**OXFORDSHIRE COUNTY COUNCIL’S RESPONSE TO CONSULTATION
ON THE FOLLOWING DEVELOPMENT PROPOSAL**

Application no: 22/02866/OUT

Proposal: OUTLINE planning application for up to 120 dwellings, vehicular and pedestrian access off Ploughley Road, new pedestrian access to West Hawthorn Road, surface water drainage, foul water drainage, landscaping, public open space, biodiversity and associated infrastructure. Access off Ploughley Road is not reserved for future consideration

Location: Land East Of, Ploughley Road, Ambrosden

Drawing Title
**Parameter Plan
Access**

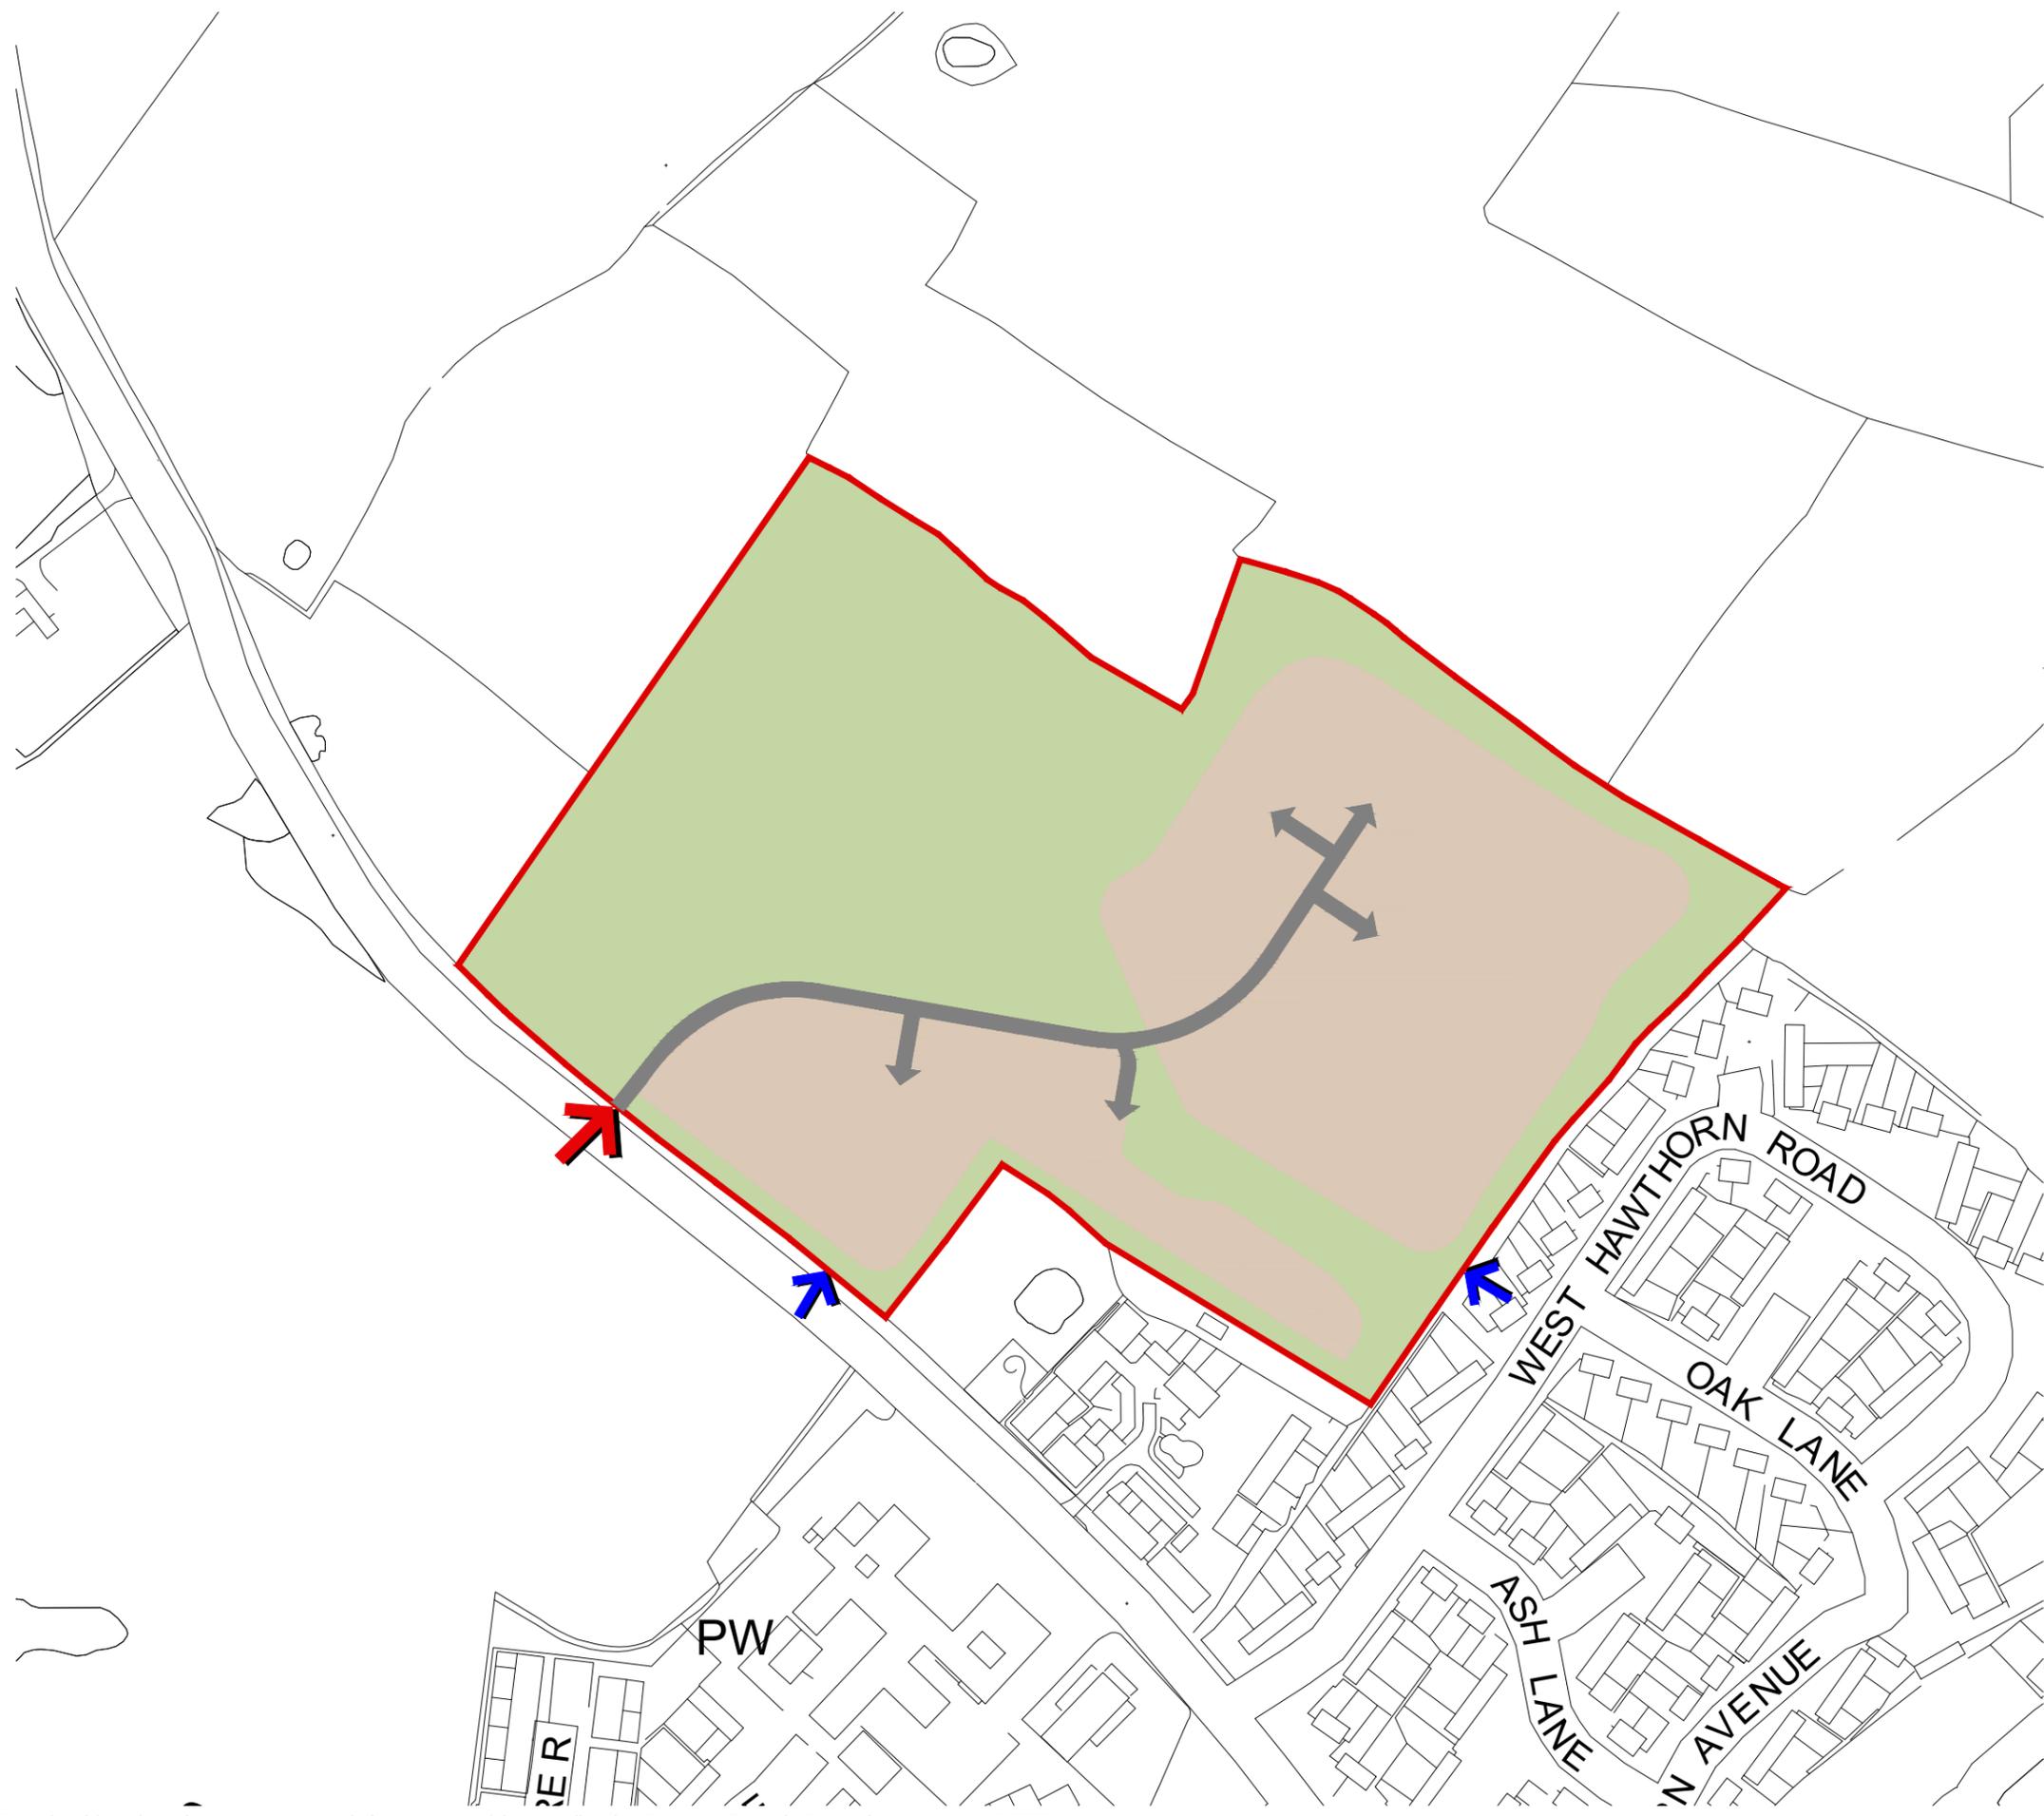
The revised proposal indicates the pedestrian access route to West Hawthorn Road connecting with bridleway 105/6/20 about 15m further north than previously shown. There is no objection to this in principle; however, the applicant should consider whether this 15m of bridleway will be re-surfaced in a manner similar to that shown in the “Existing Track Connection to On Site Development” drawing included in the Transport Assessment Addendum. Any new path surface should follow the desire line.
